Current Zoning: N1-B (Neighborhood 1)  
Proposed Zoning: UR-2(CD) (Urban Residential, Conditional)

Approximately 2.73 acres located east of S Tryon Street, south of Nations Ford Road, and north of Skipwith Place.

The petition proposes to allow 33 single family attached dwelling units on a vacant property on S Tryon Street.

RZ-1

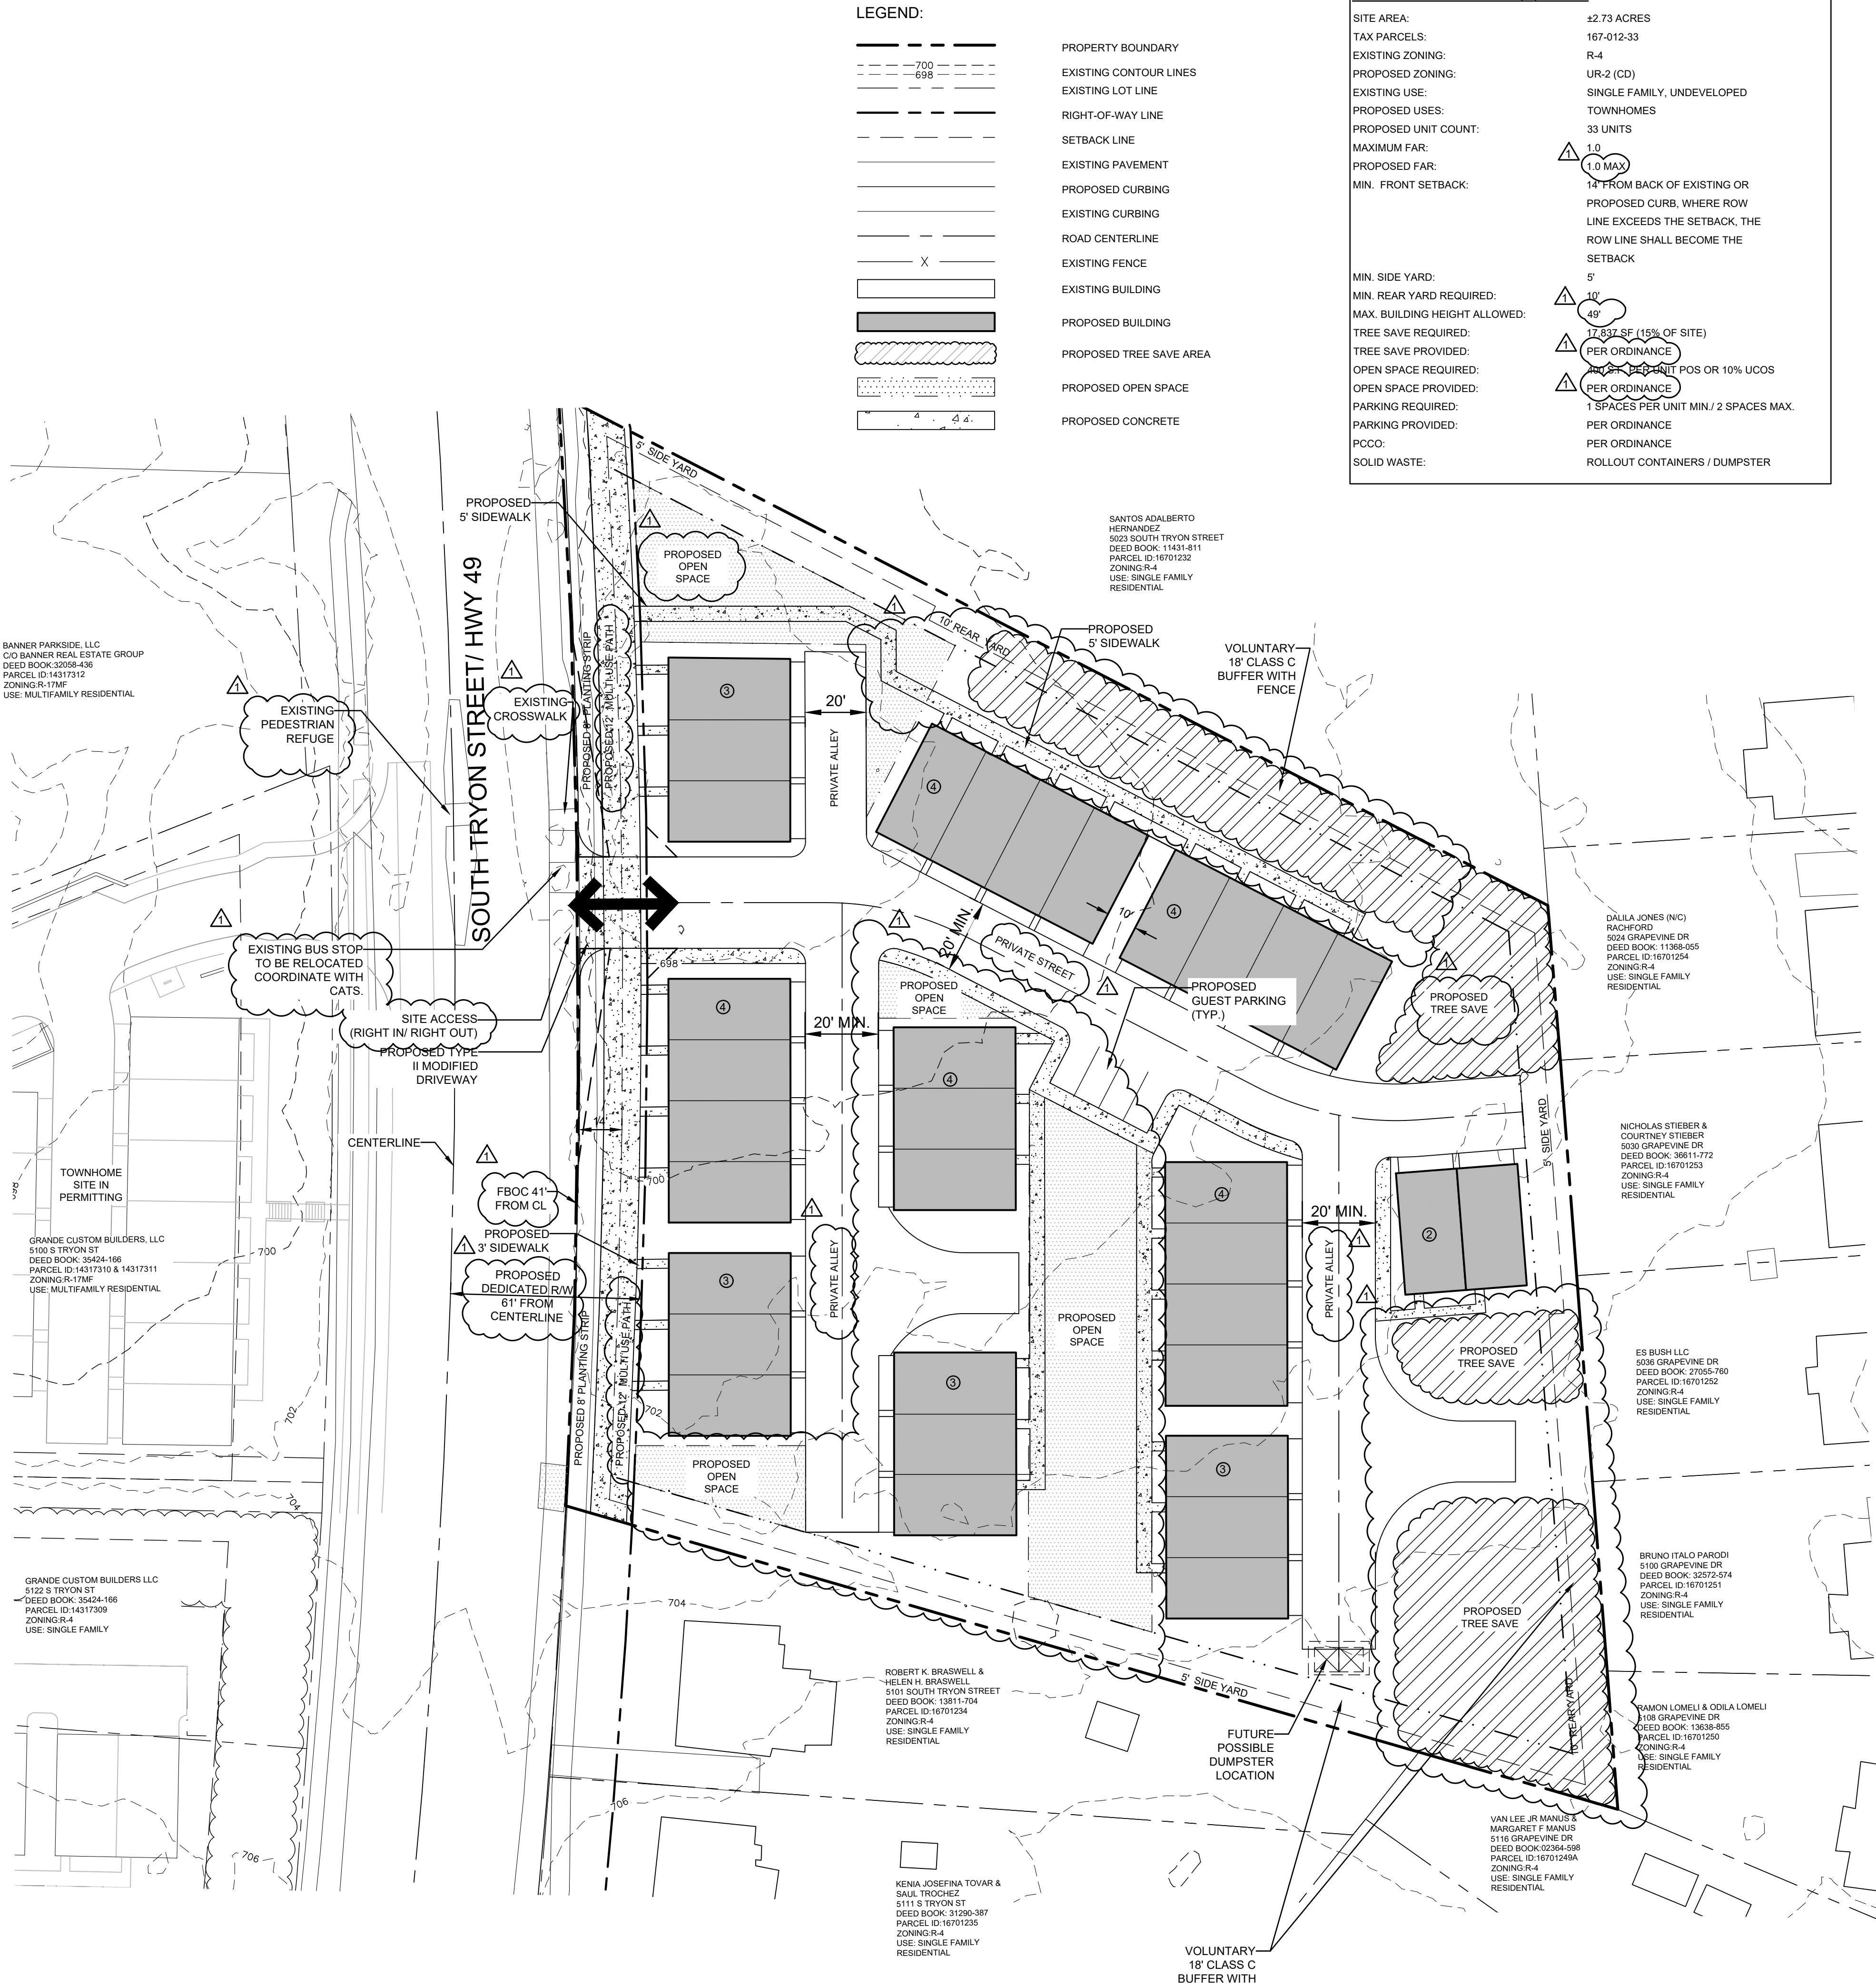
- ~~2. Increase minimum setback of S Tryon Street to 20 feet.~~ **ADDRESSED**

- Establishes a 27' setback from future back of curb.
- Commits to the following transportation improvements:
  - Dedicates 61' of right of way from the centerline of S Tryon Street.

RZ-2

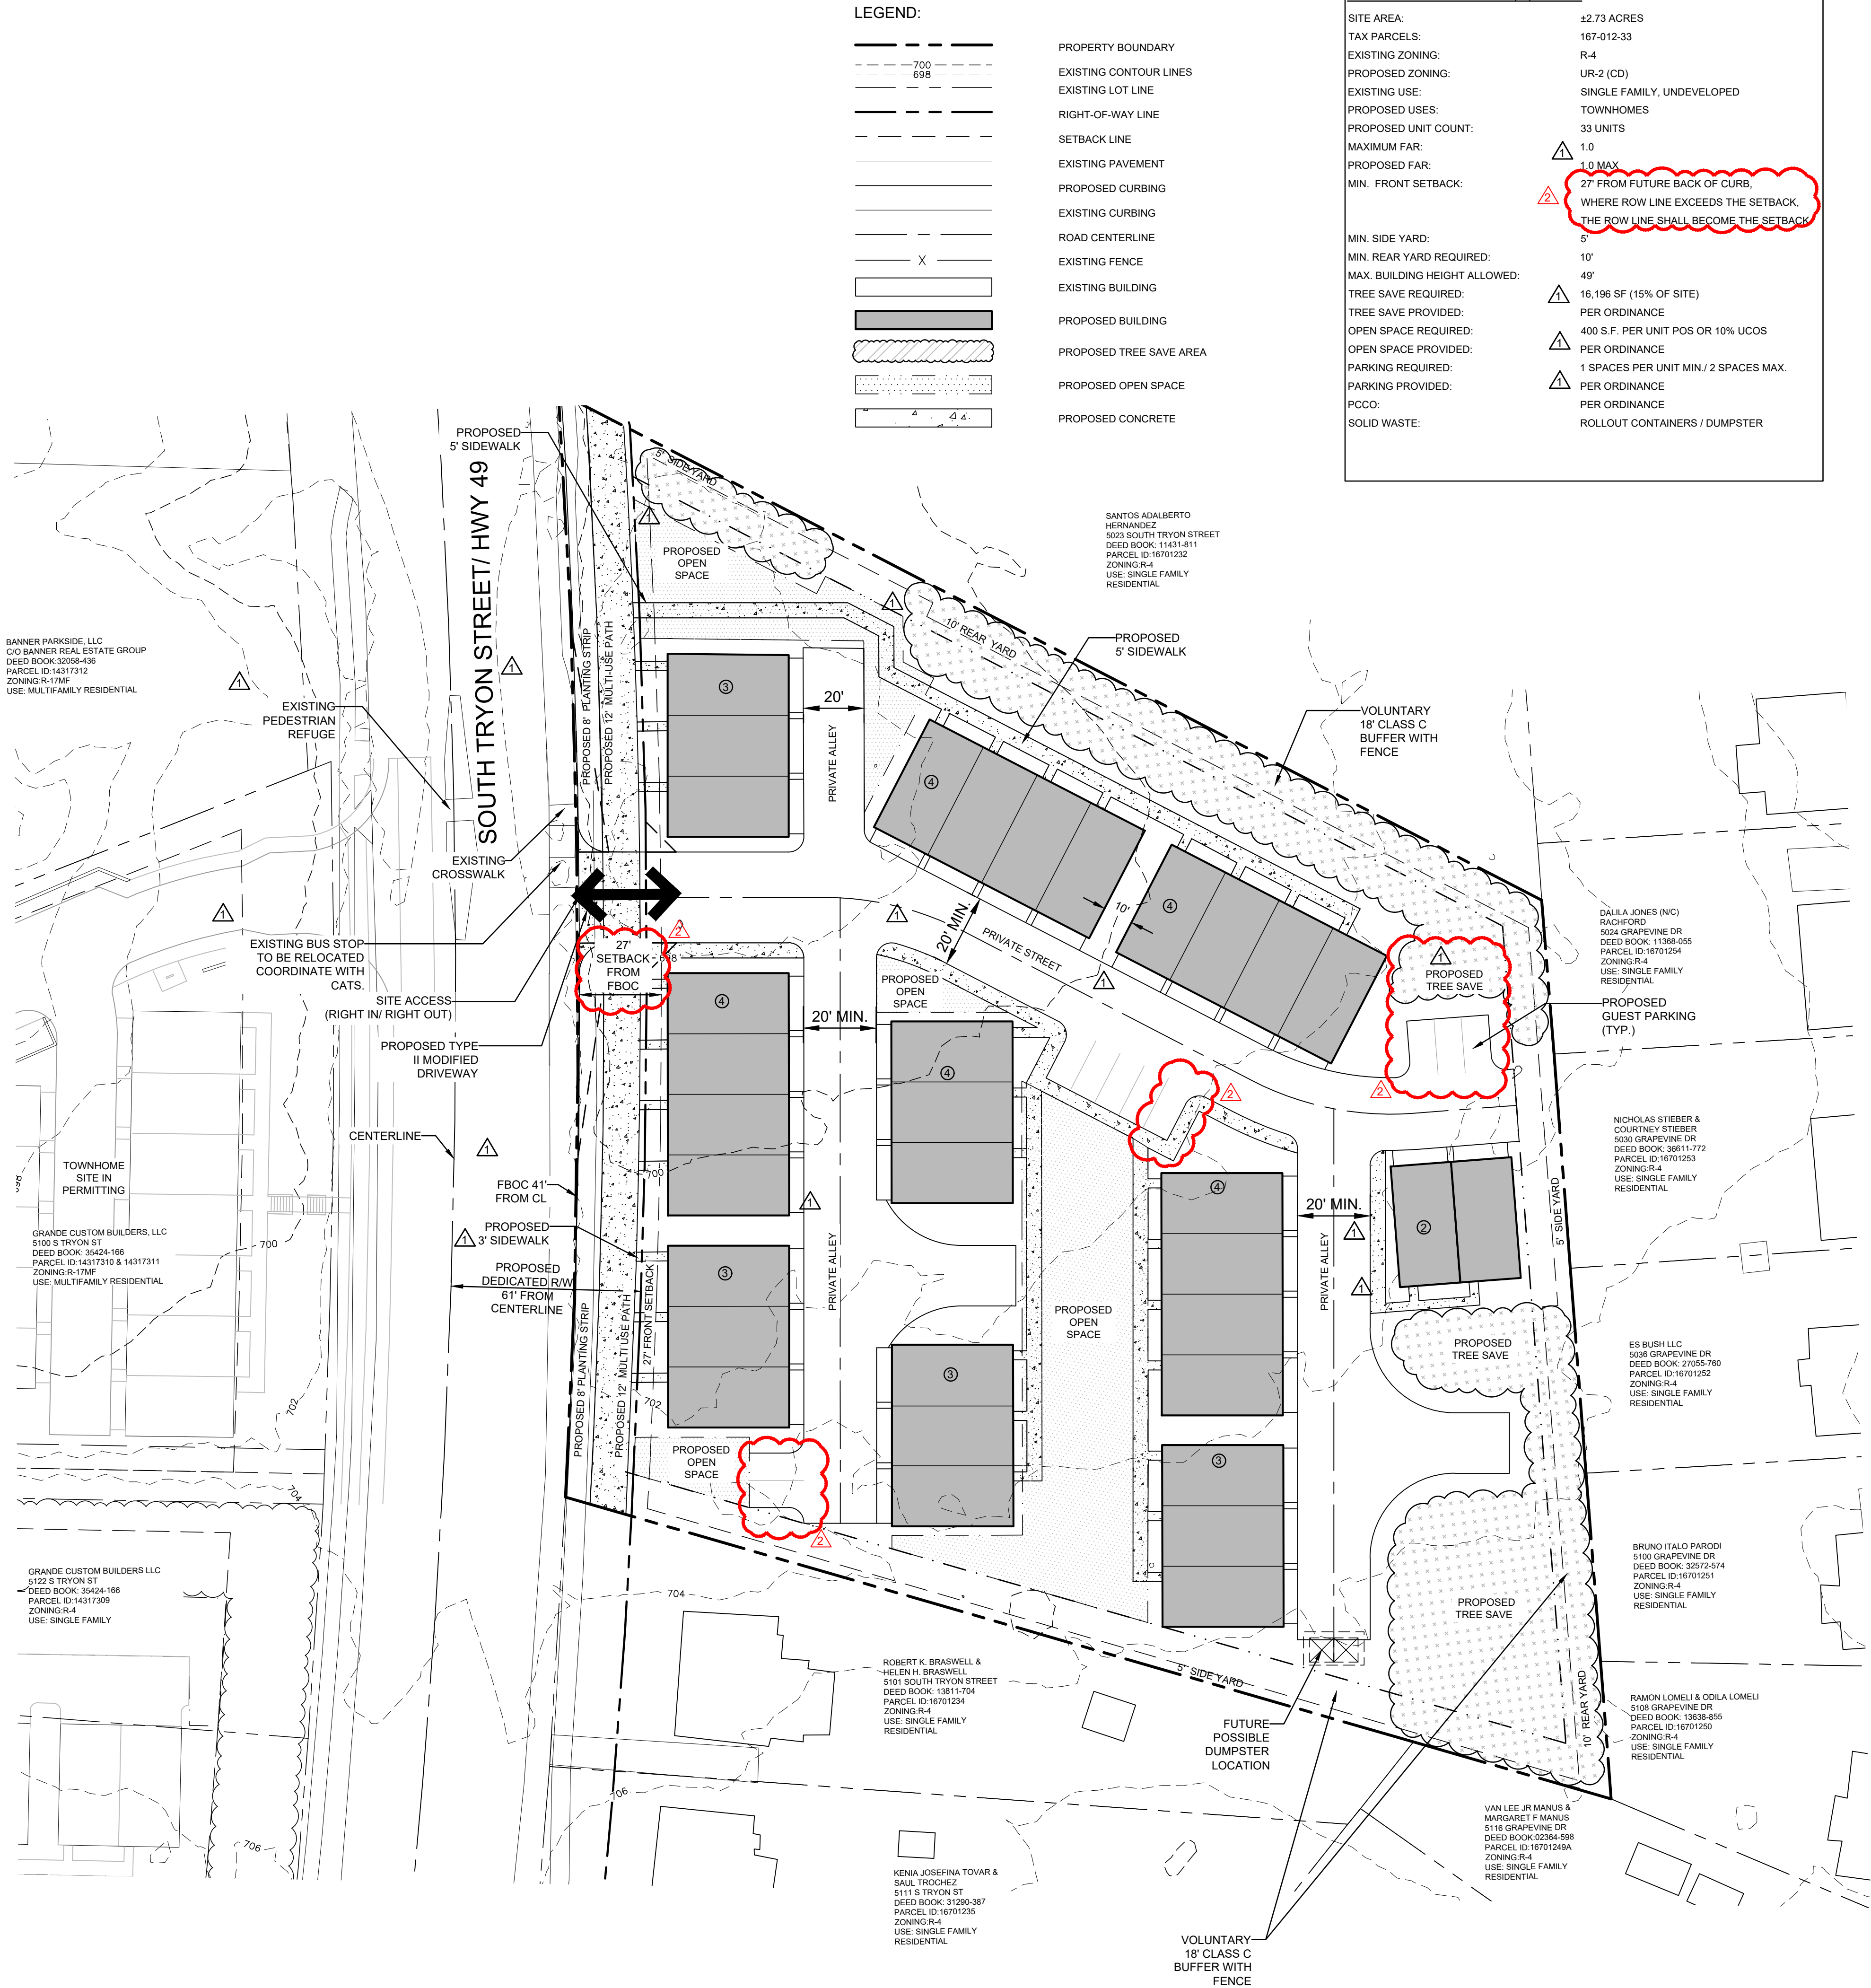
- ~~1. Remove the following language from note C.8: "required to be constructed by petitioner under this section C of the development standards."~~ **ADDRESSED**
